From: Anthony.Collier@hertfordshire.gov.uk
To: [Planning](#)
Subject: Planning application 6/2016/0616/FULL - 2 De Havilland Close
Date: 05 August 2016 09:51:00

Response to Planning application from Hertfordshire County Council (T and CP GDP Order 2015)

District ref: 6/2016/0616/FULL

Conversion of dwellinghouse into 2no dwellinghouses

SCALE: 1:100 JOB/DRG. No:-  
 DATE: Mar 2016 2016-064A

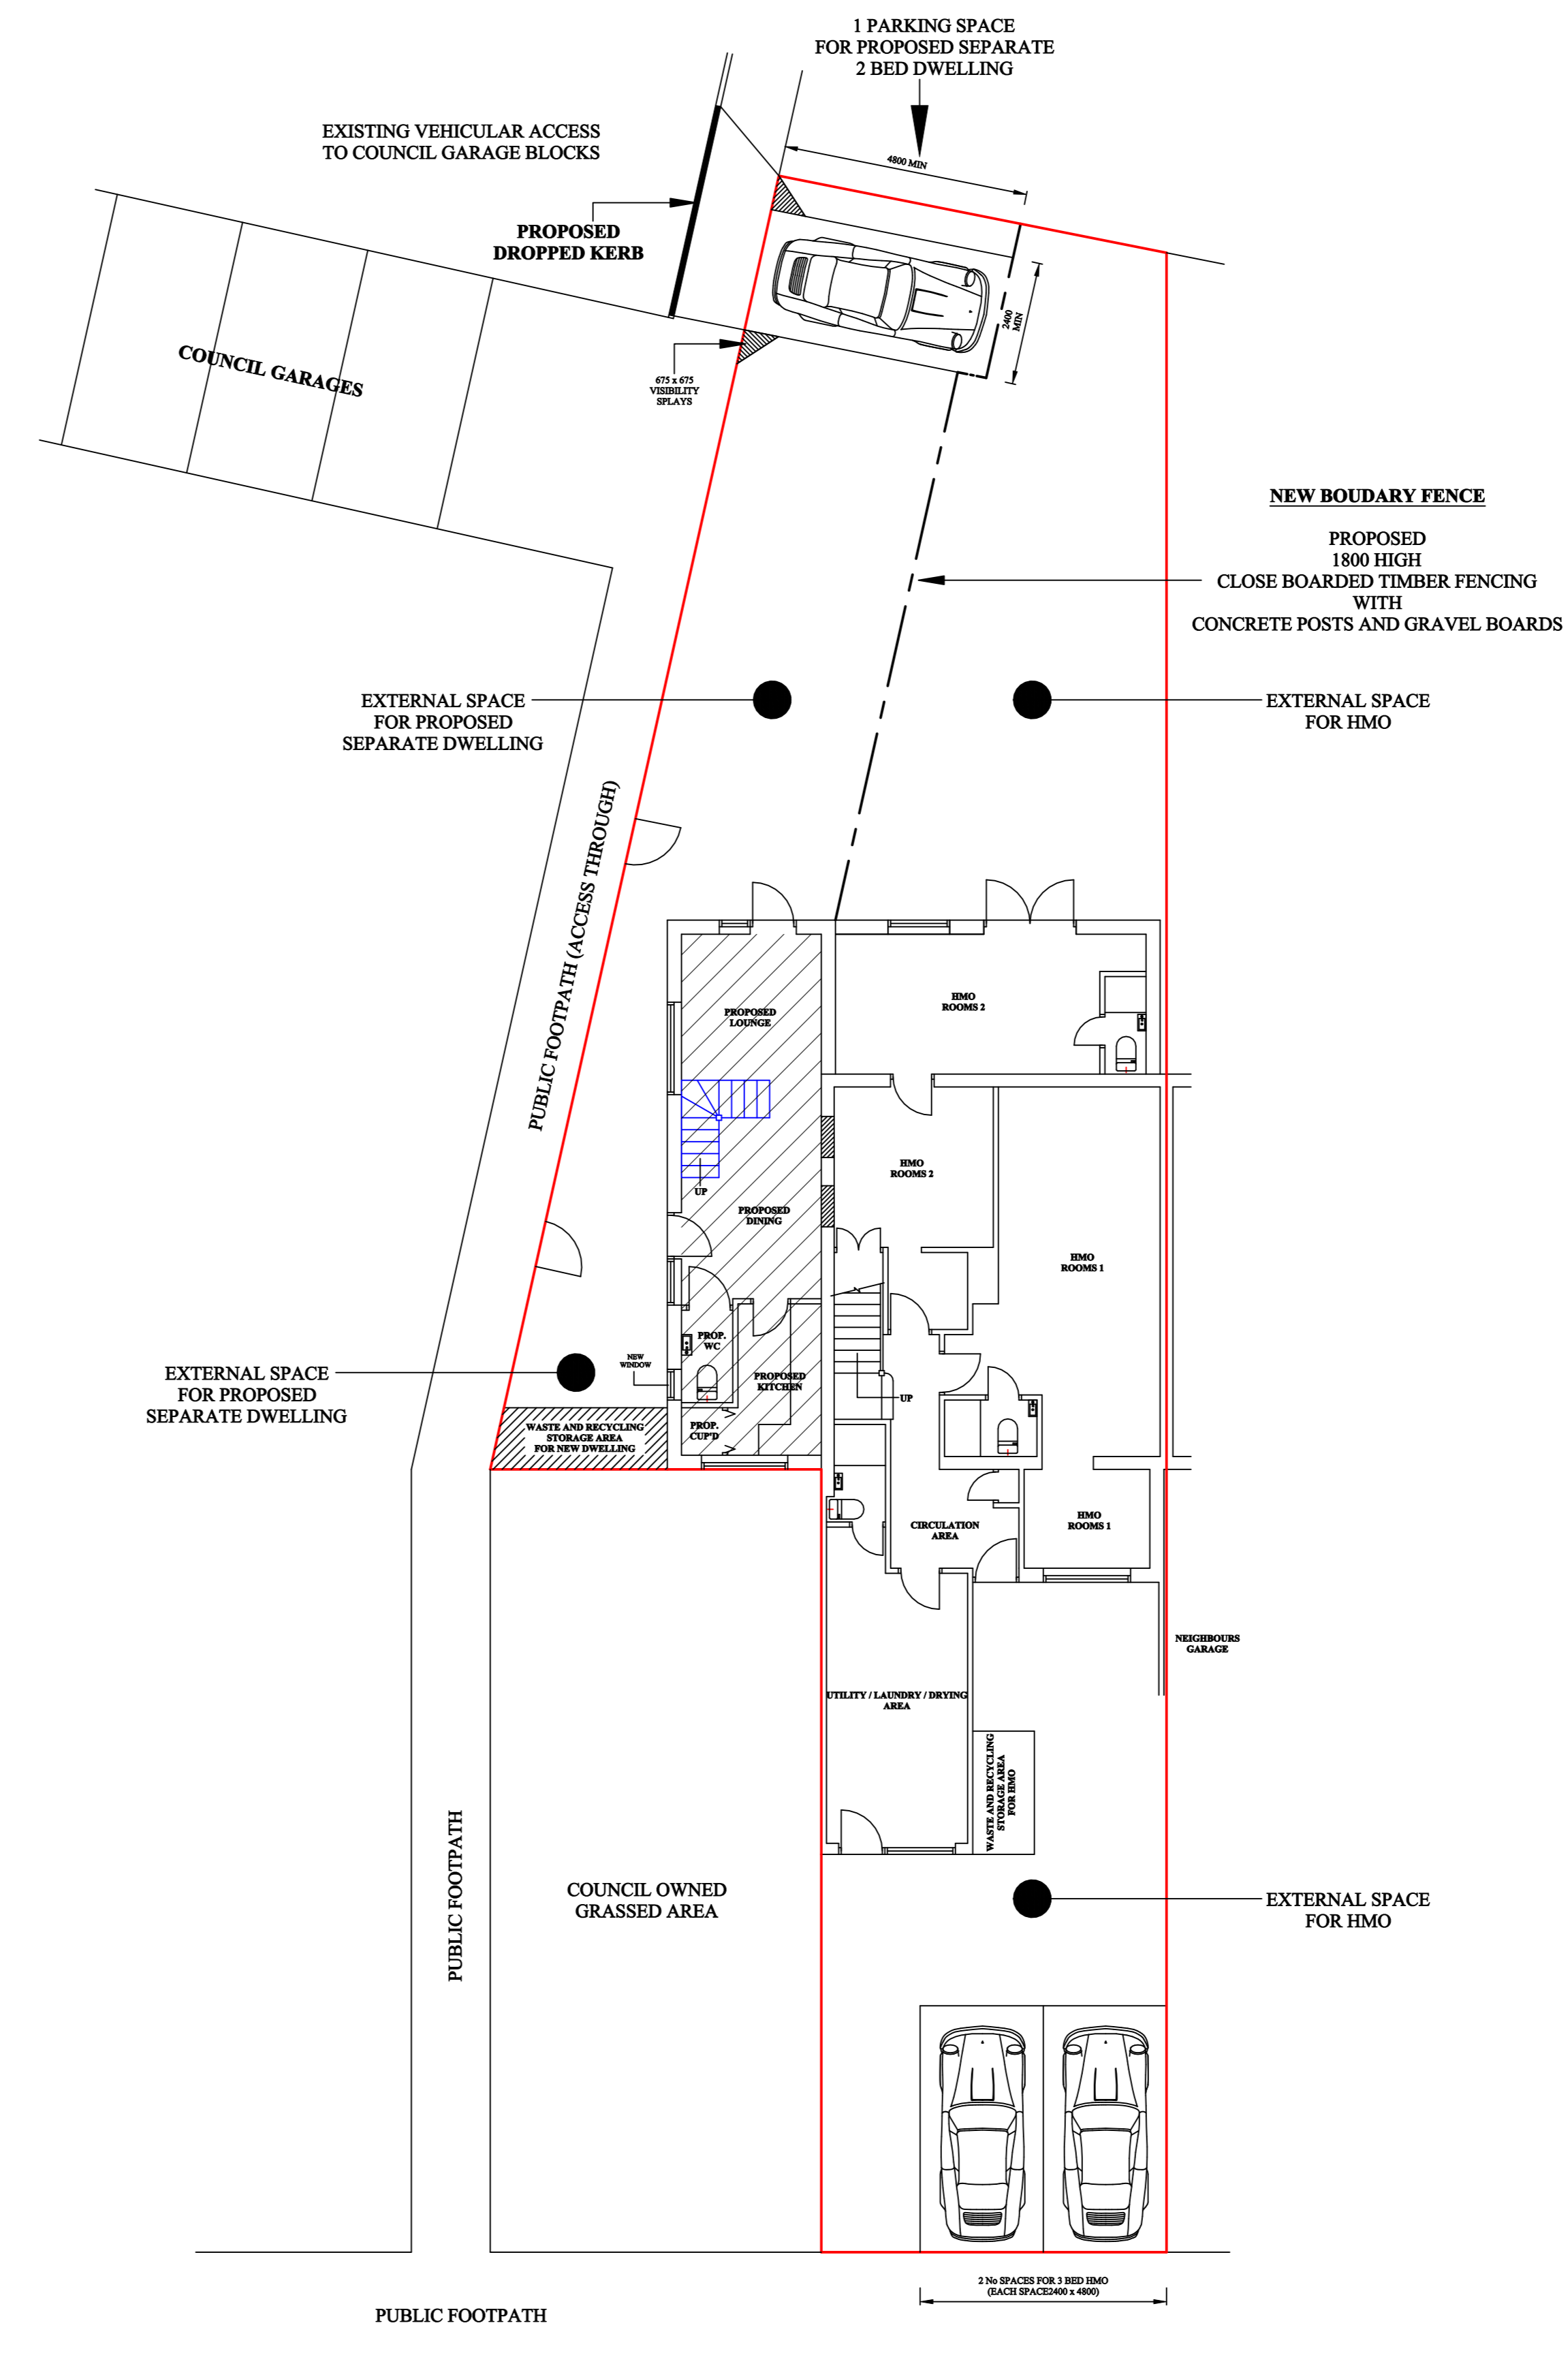
The application site is for the Conversion of dwelling house into 2no dwelling houses located within the existing residential area De Havilland Close in Hatfield. It is noted that in the planning application form whilst the extension is for one dwelling into two, the current dwelling is laid out as a four bedsit dwelling, and will remain so in the proposal. It is proposed that vehicular access to the site will be provided via a new entrance and crossover and driveway via De Haviland Close, Council owned garage Complex. The proposed access would provide three off-street parking spaces, with the site currently having three existing spaces. The planning application form states that the proposed parking provision and refuse provision shall be that set out in drawing 2016-064A.

The LPA would be advised that the new access proposed via the 'council owned garages', uses an unadopted road, not maintained by the Highway Authority.

I note that three parking spaces are provided to the property, and 2016-064A shows a driveway with pedestrian visibility considered for.

The location of the driveway with access to the garage complex should be reviewed by the LPA regarding adequacy of access.

For the existing property, the design retains the use of the existing vehicle cross over with no changes or amendments outlined.

It is recommended that the LPA use this opportunity to review the application with regard to Hertfordshire County Council Environment Department -Residential Dropped Kerbs Terms and Conditions

Refuse provision is outlined for the new and existing dwellings and would be suitable.
